## Local Policing Support Team

Our Ref: PE/ARU/20/09/A

Date 21<sup>st</sup> April 2020

**RE: Land North of Sefter Road & 80 Rose Green Road, Pagham.**

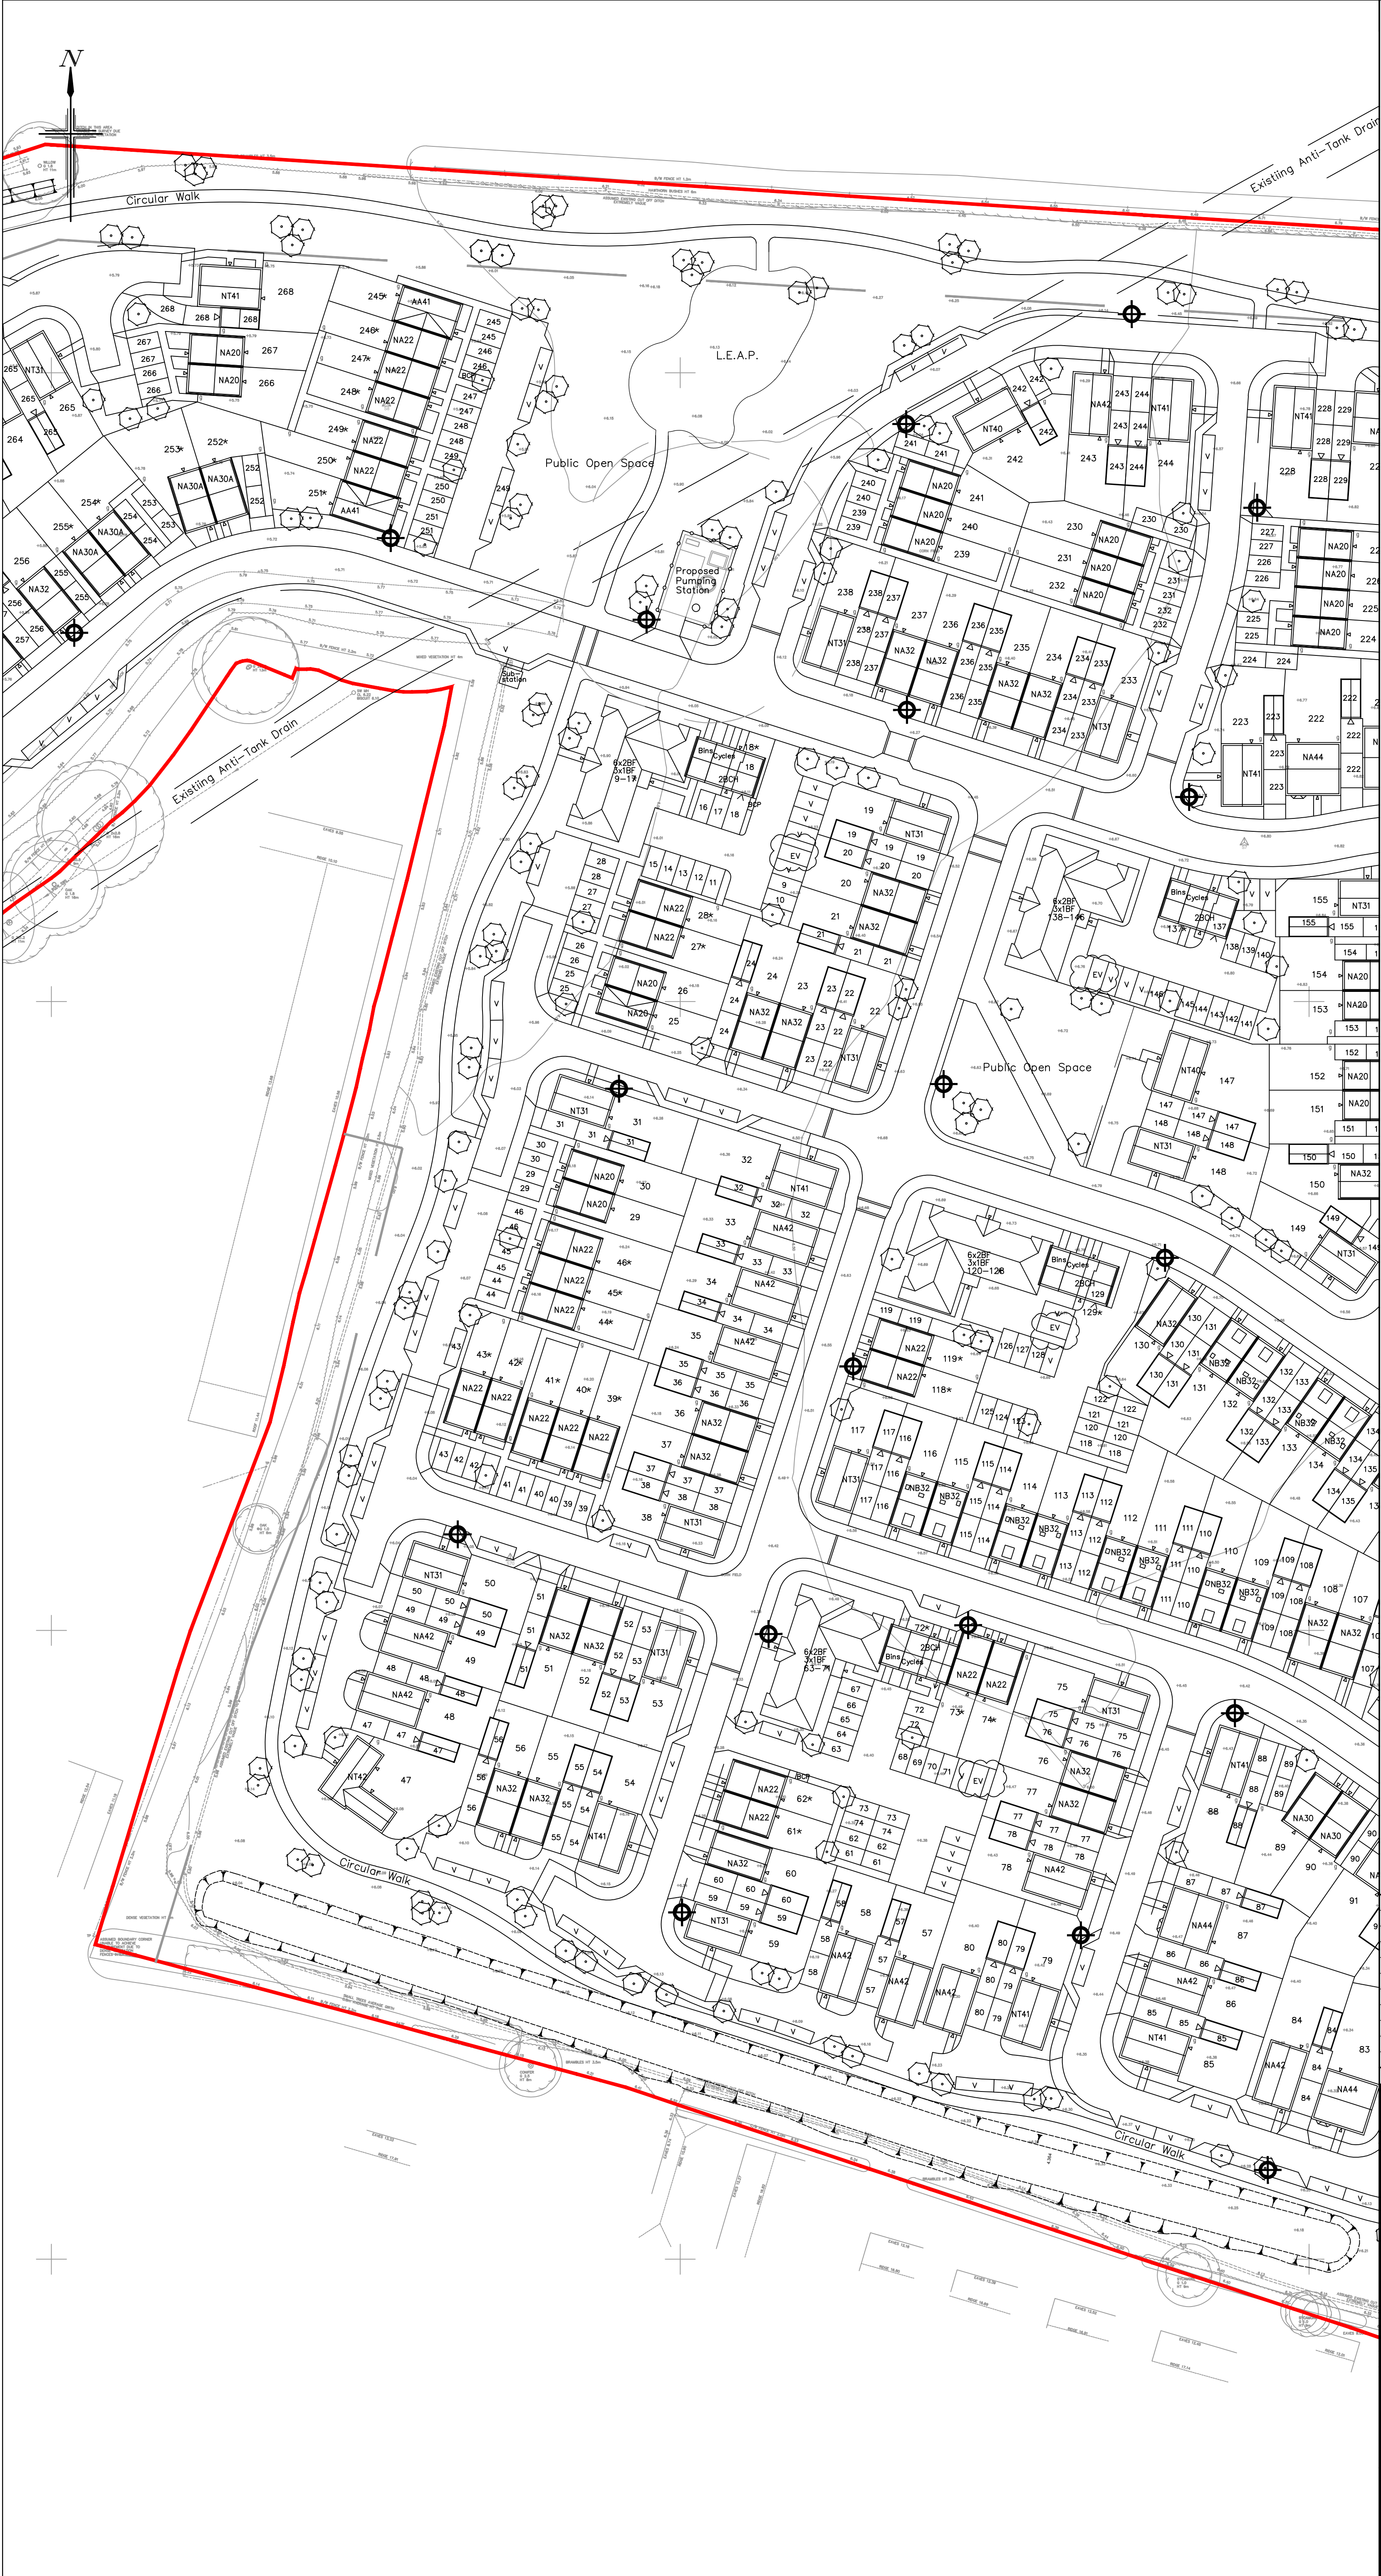
I was pleased to note the inclusion of lighting columns throughout the development. I ask that the lighting levels conforms to those within BS 5489-1:2013.
